**Application for a non-material amendment following a grant of planning permission,
Town and Country Planning Act 1990**

**Non material amendment to previous permission 2018/93963 for erection of two
storey rear extension**

21, Oakland Court, Highburton, Huddersfield, HD8 0XF

Application Number: 2021/92735

DRAWING NO
3151/3

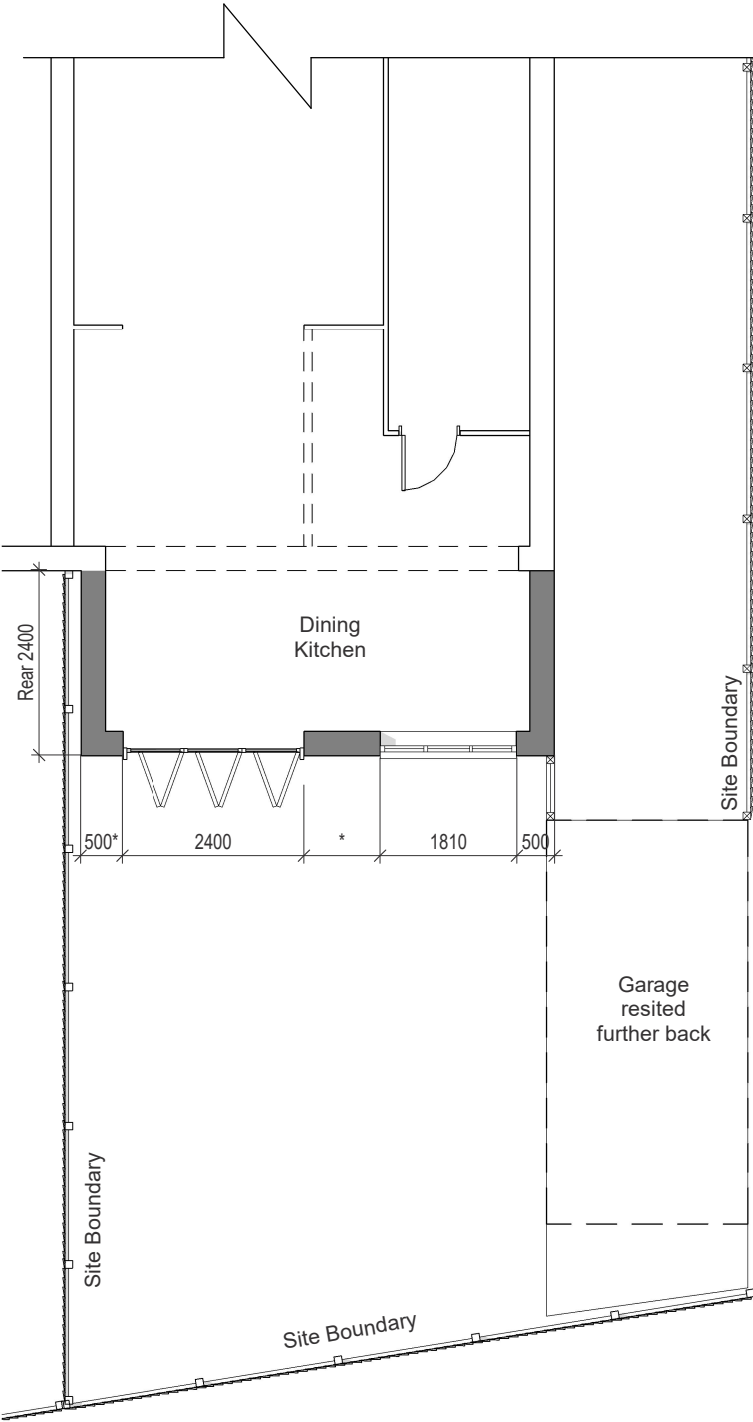
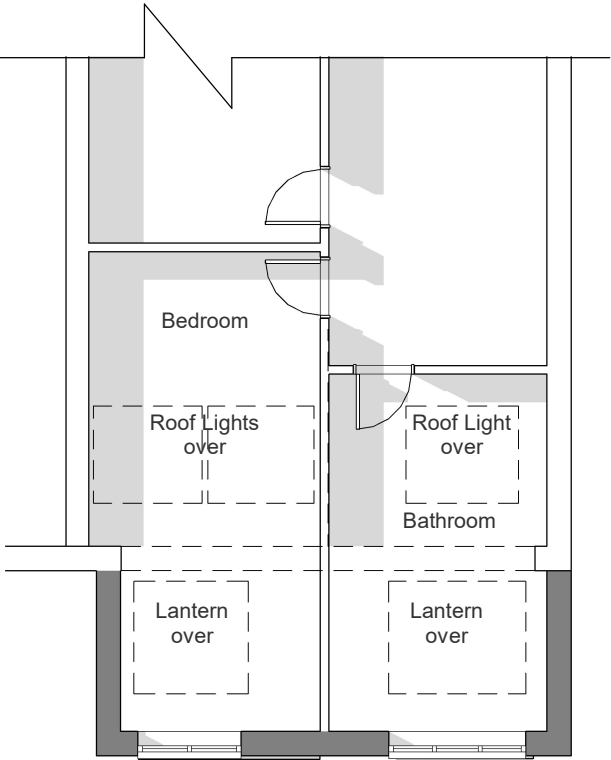
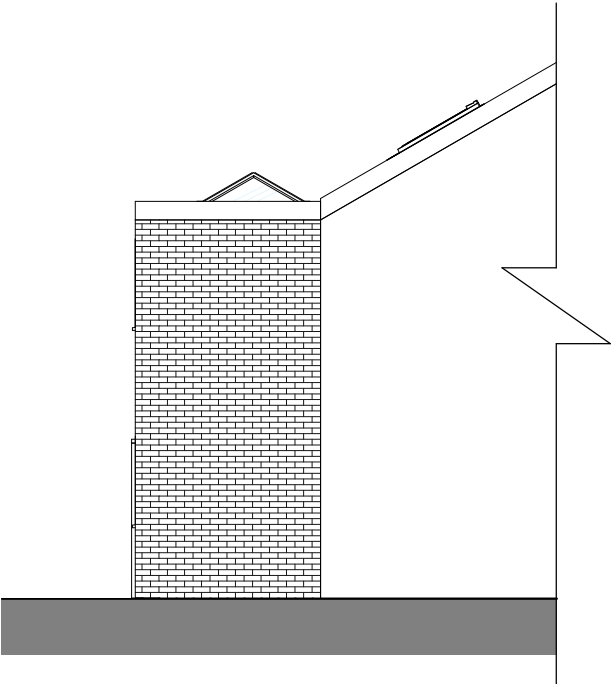
- Roof amended from apex to flat roof with overall extension reduced in height. Proposed rear extension includes two roof lanterns and the existing rear roof to include 3 sky lights.

This amendment is set out in drawing number: 3151/3 A

It is considered to fall outside the scope of being a non-material amendment as in officers' opinion the proposal would significantly alter the appearance of the approved two storey rear extension.
